Rezoning Transportation Analysis

Petition Number: 2020-200

Reviewer: Kevin Parker, PE
Kevin.Parker@charlottenc.gov
704-432-6511

Revision Log:	Date	Description
	12-28-2020	First Review (KP)

RZ-1.0

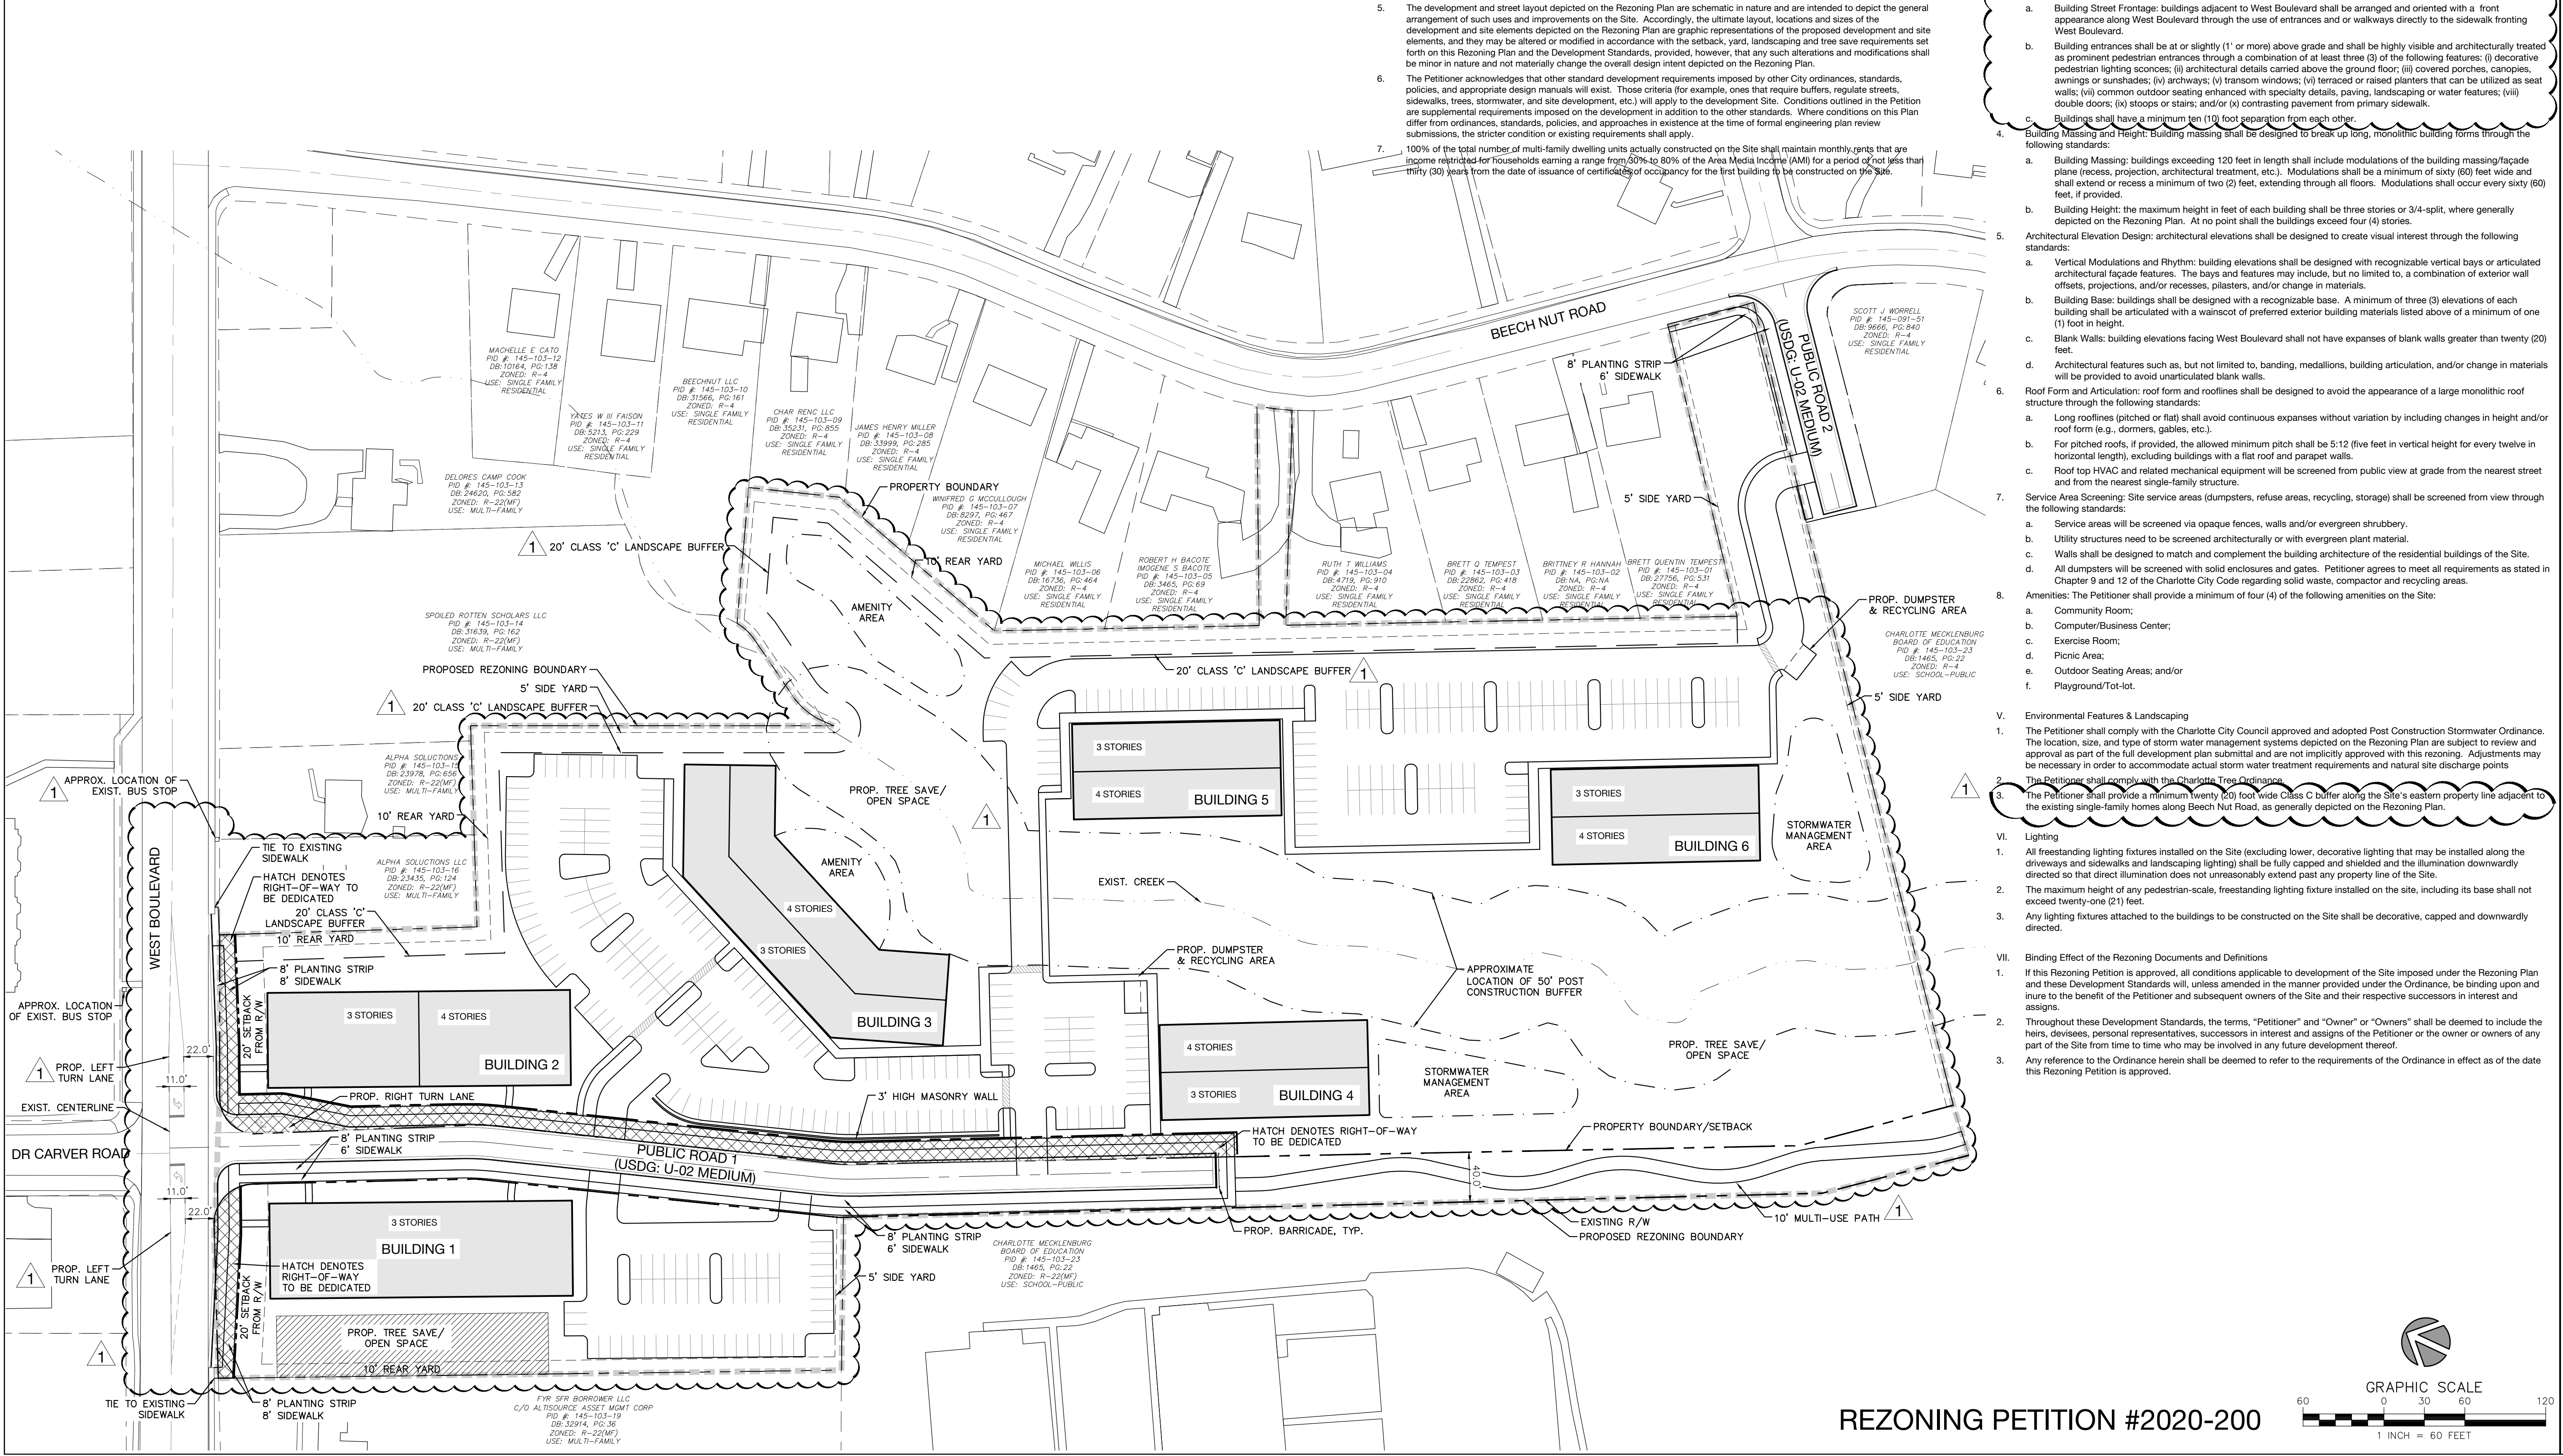
- a. **West Boulevard:** Relocate the existing curb and gutter to the future location at 38-feet from the road centerline to back of curb, to accommodate a future 4-lane Avenue road cross section with buffered/separated bike lanes and left-turn lanes.

Label and dimension the curb and gutter from the centerline for each road on the site plan.

- a. **West Boulevard:** Revise site plan and conditional note(s) to commit to dedicate 56-feet of right-of-way from the road centerline, to provide 2-feet behind the proposed sidewalk.
- b. **Paper Right-of-way:** Revise the site plan and conditional notes to dedicate 56-feet of total right-of-way, 28-feet of right-of-way from the paper right-of-way centerline.

Label and dimension the right-of-way from the centerline of each road on the site plan.

- 4. Revise site plan and conditional note(s) to commit to construct an 8-foot planting strip and 8-foot sidewalk on West Boulevard, as well as an 8-foot planting strip and 6-foot sidewalk on Proposed Public Roads 1 and 2, unless otherwise required by the Subdivision Ordinance. The site plan needs to label and dimension both items from the road centerline.

- 5. In accordance with the Charlotte BIKES Plan, revise the site plan and conditional notes by committing to the construction of an 8-foot buffered bike lane along the site's West Boulevard frontage. The site plan needs to label and dimension the buffered bike lane from the road centerline.

6. Revise the site plan and conditional notes by committing to the construction of two left-turn lanes, on West Boulevard, and providing left turning movements onto Dr. Carver Road and Proposed Public Road 1. Additionally, signal modifications will be required to accommodate the additional left-turn lanes and the addition of Public Road 1 as the fourth leg of the intersection. These improvements will be required to be built to NCDOT Standards.

7. Revise the site plan and conditional notes by providing a designated right-turn lane on Public Road 1, to turn onto eastbound West Boulevard, and a combined through/left-turn lane to cross West Boulevard or to turn onto eastbound West Boulevard.

8. Revise the site plan and conditional notes by committing to the construction of an internal, 12-foot wide, shared-use path to connect the development area for proposed Buildings 4 and 5 to the development area for proposed Buildings 1, 2, and 3.

9. Revise the site plan and conditional notes by committing to coordinate with Charlotte-Mecklenburg Schools (CMS) to provide a pedestrian connection/access to the Irwin Creek Greenway. The ICG currently has a trailhead located within the adjacent property of the Berringer Academic Center.

10. Revise the site plan and conditional notes by committing to coordinate with CATS, during permitting, to make improvements to the existing bus stop on West Boulevard. The site plan needs to show the existing bus stop.
